Final Acceptance (FA) Punchlist
EPC - DPW - Stormwater Section

Project Name:	Super Star Car Wash
EDARP Filing Number(s):	PPR218
ESQCP Number:	ESQ2211
Attendees:	DPW SW: Erica Rylander DPW Planning: Brad Walters, David Parkerson Developer: Matt Horton
Date of Walk-Thru:	3/20/2023
Walk-Thru Number:	1 st

FINAL EROSION CONTROL PLAN
SUPER STAR CAR WASH - FALCON MARKETPLACE LOT 10
GRADING AND EROSION CONTROL PLAN

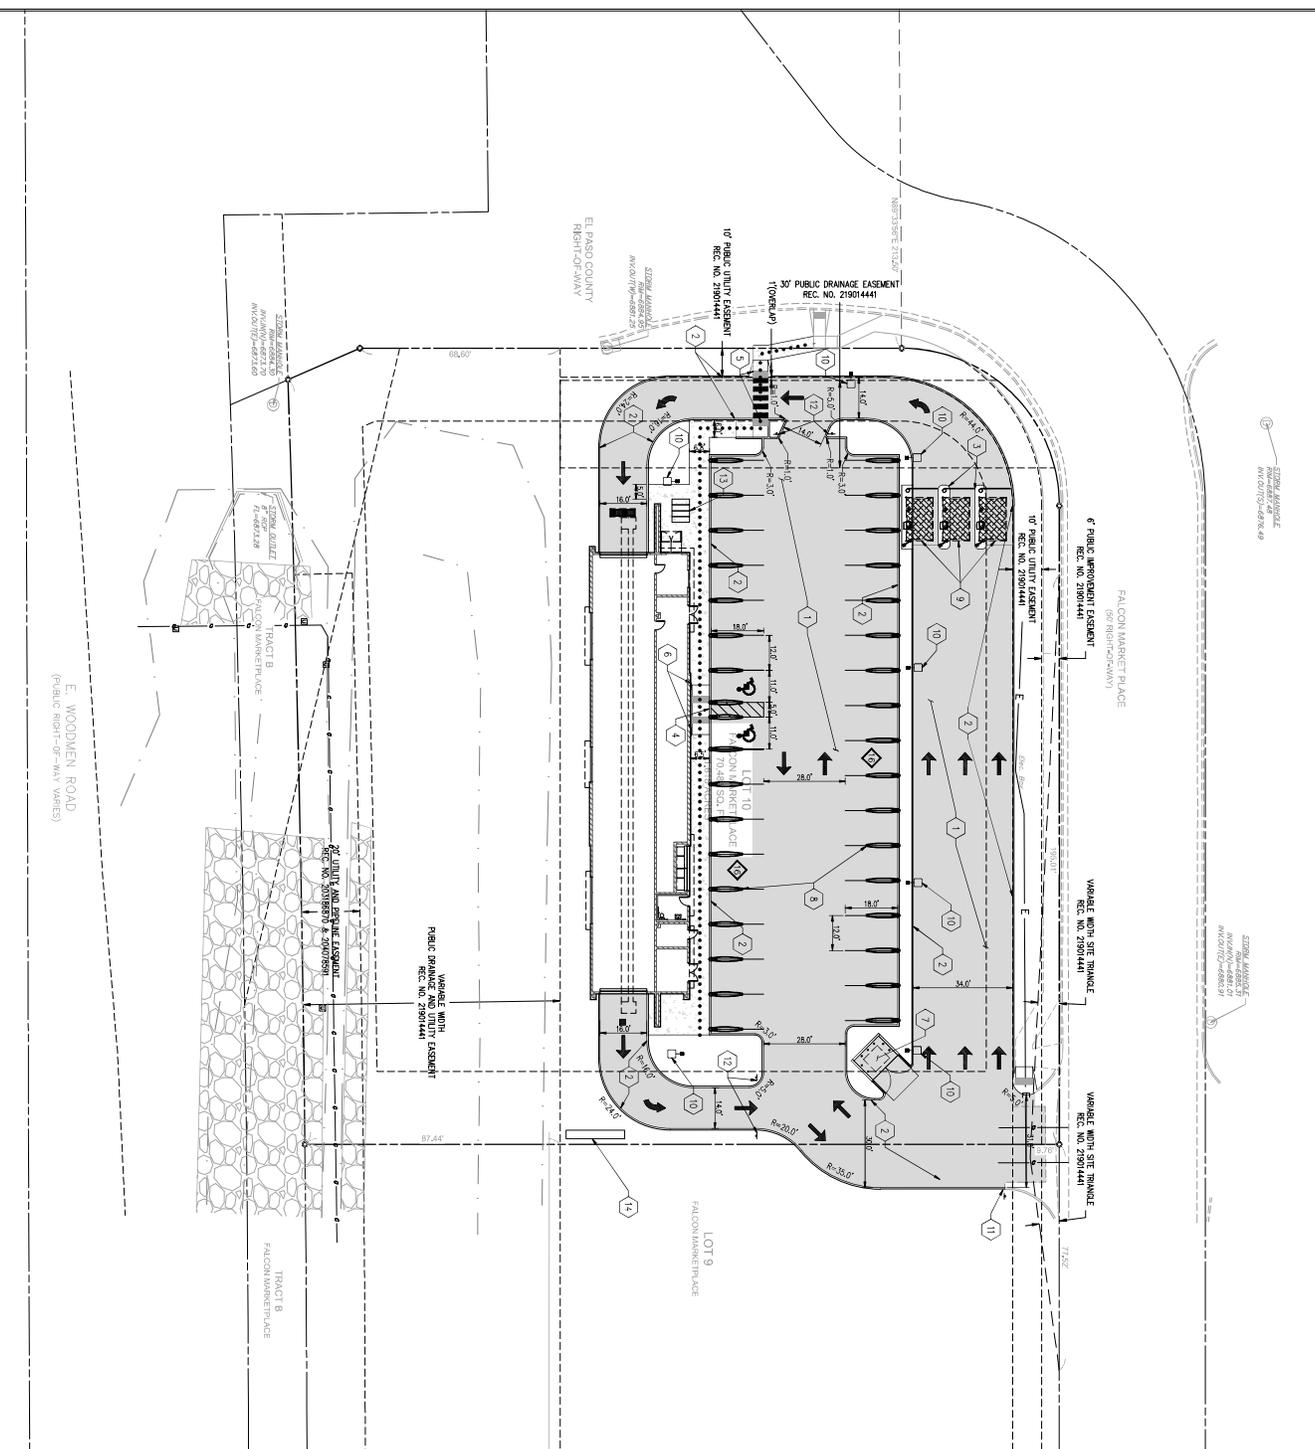
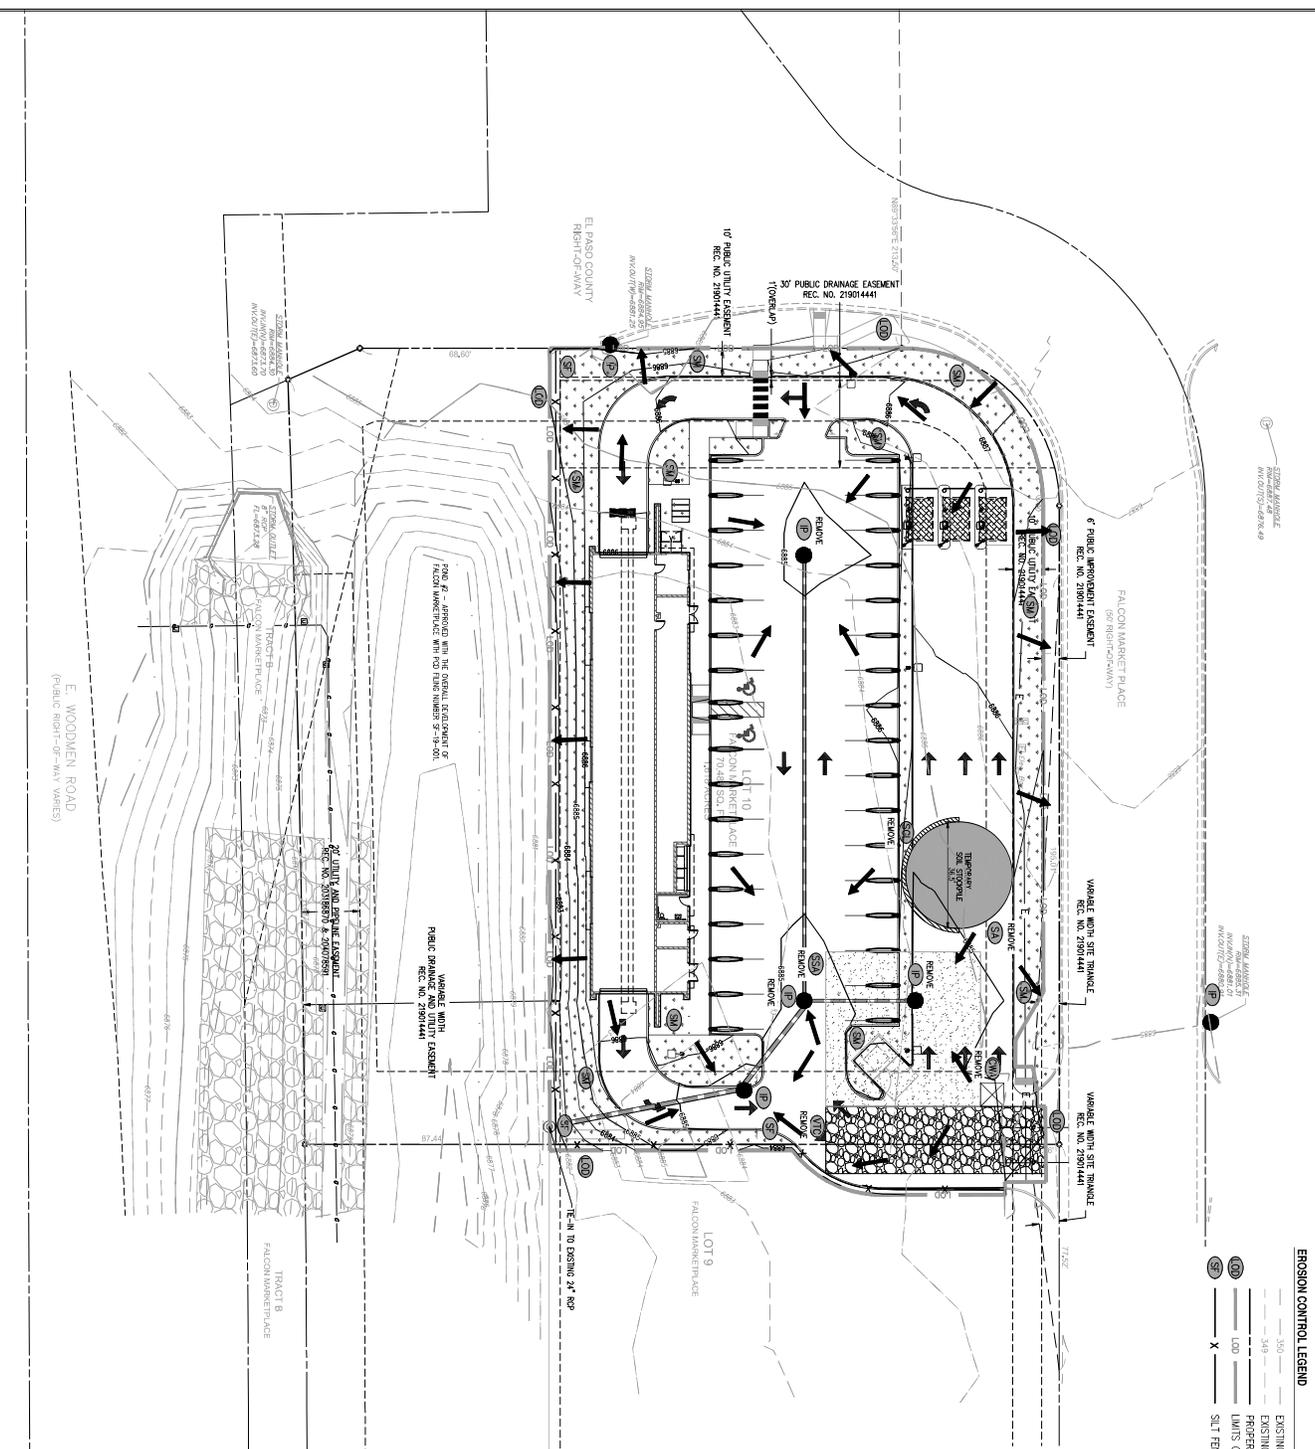
- Remove straw wattles from south side of building.
- Re-install erosion control blanket on slope on south side of building per detail.
- Implement final stabilization measures (i.e. seed and hydromulch/straw mulch) in areas south of site that were disturbed during vertical construction.

Photo 1: On south side of building: remove straw wattles and re-install erosion control blanket per detail.

Photo 2: Implement final stabilization measures throughout bottom of pond in areas disturbed during vertical construction.

Photo 3: Implement final stabilization measures at southwest corner of site in areas disturbed during vertical construction.
